CITY OF ALBUQUERQUE

RE: **Lot 4A Block 9 Unit 18, S.A.D. 228**
Volcano Cliffs Subdivision
7904 Aguila NW
Grading and Drainage Plan
Engineers Stamp Date; 6-19-17 (D10D00I4)
Pad Certification Date; 9/18/17

Based upon the information provided in your submittal received 10/2/17, this plan cannot be approved for pad certification until the following comments are addressed.

BURK - GRADING & DRAINAGE PLAN

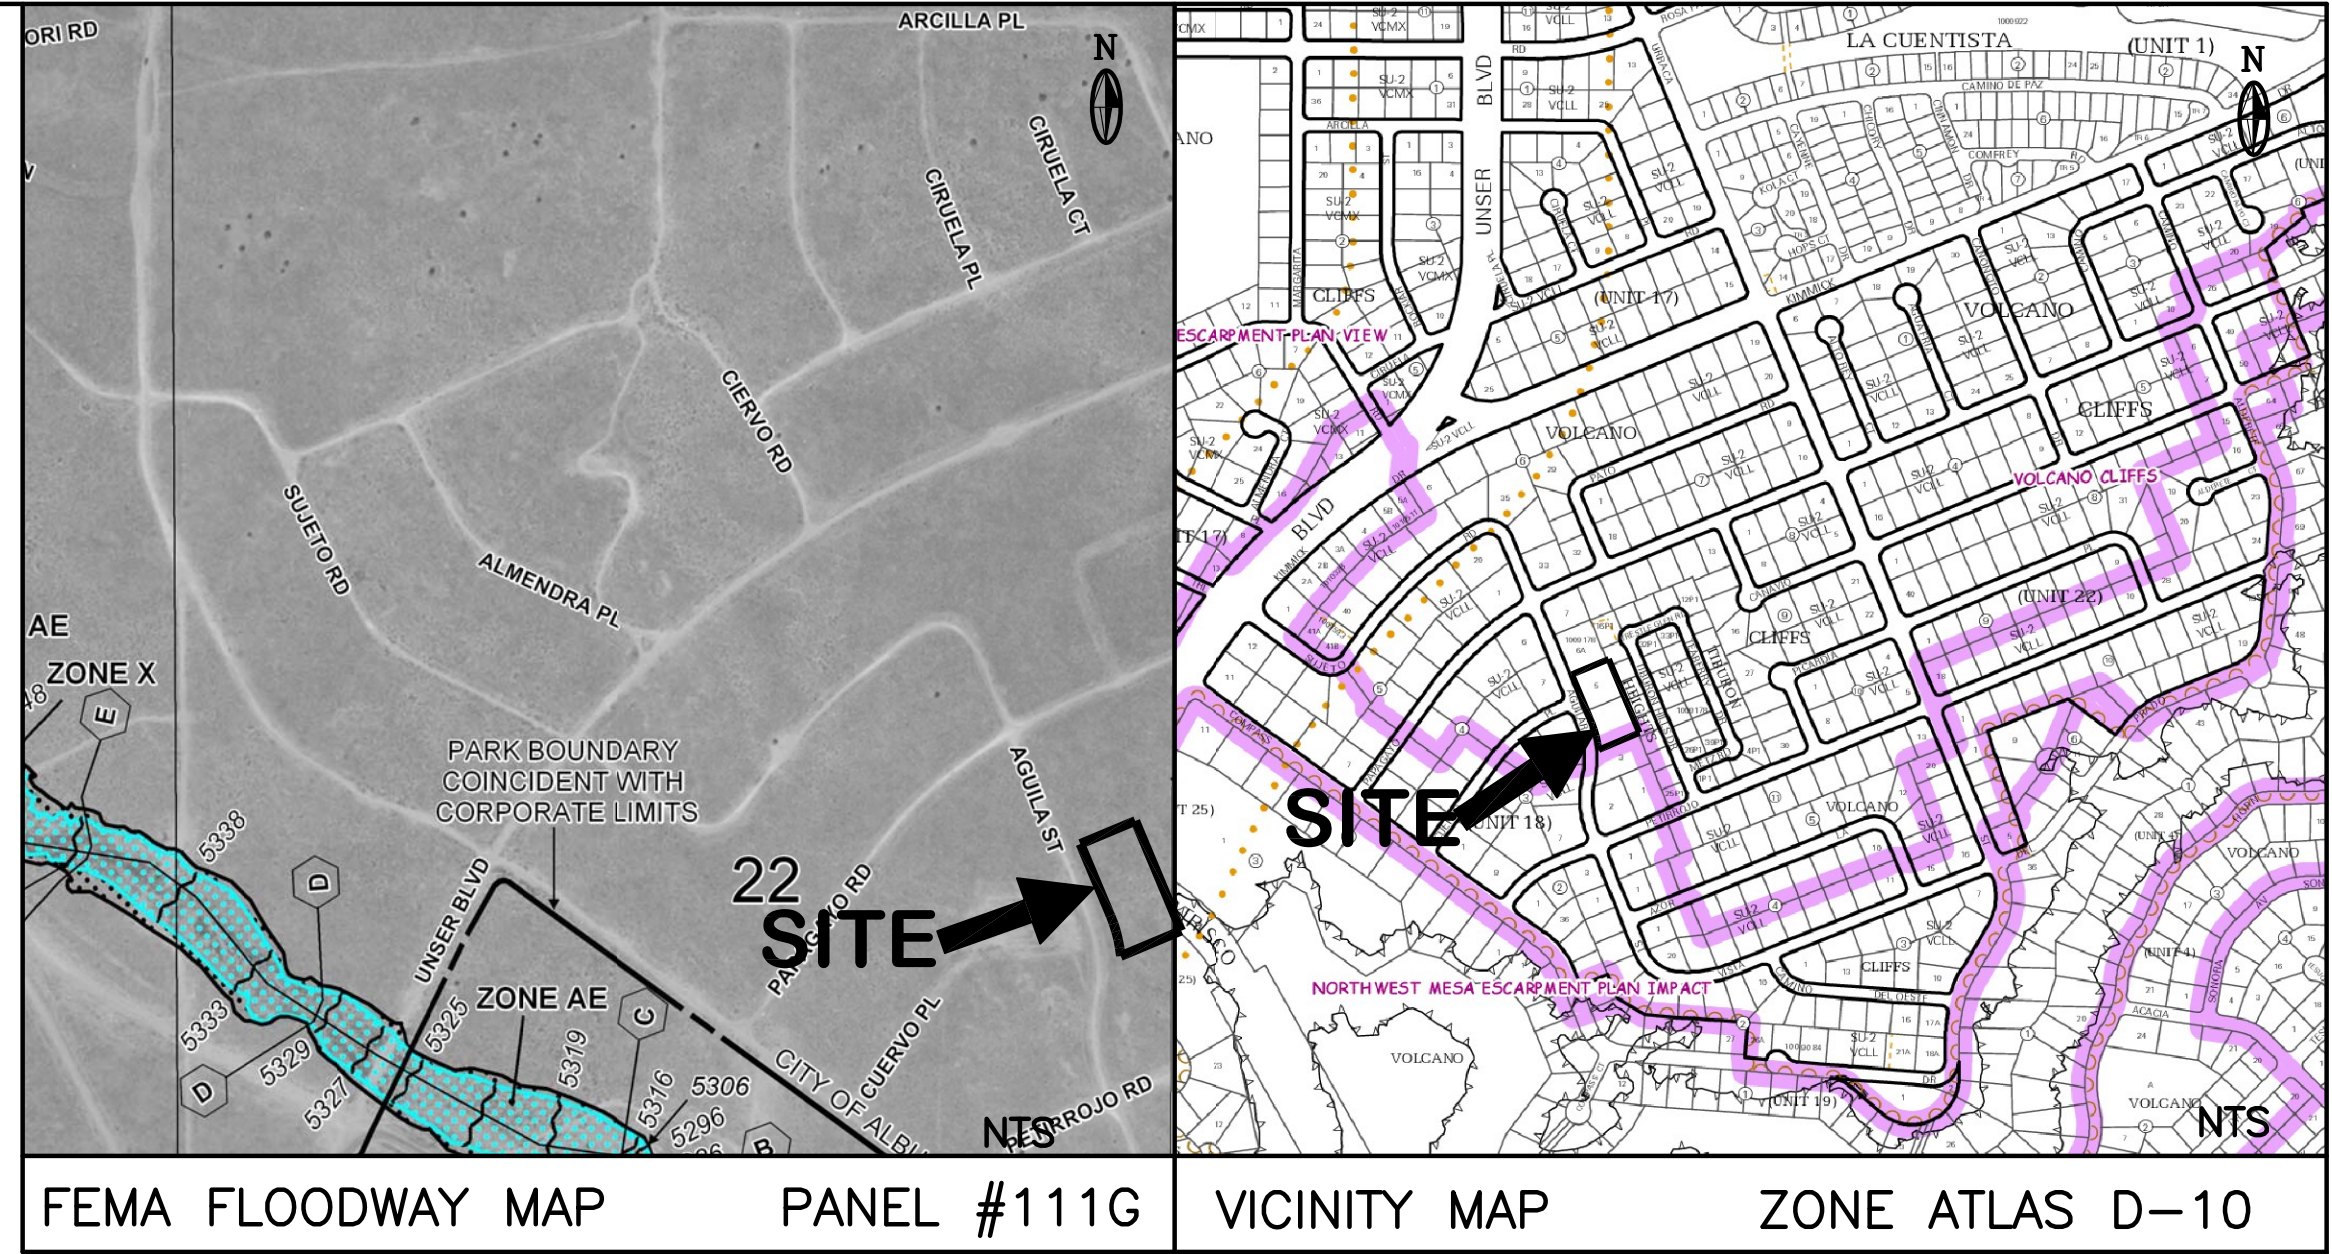
- Correct the Pad Certification language, and the discrepancies between the finished floor benchmark and the average elevation of the building pad.
- Define the finished floor benchmark.
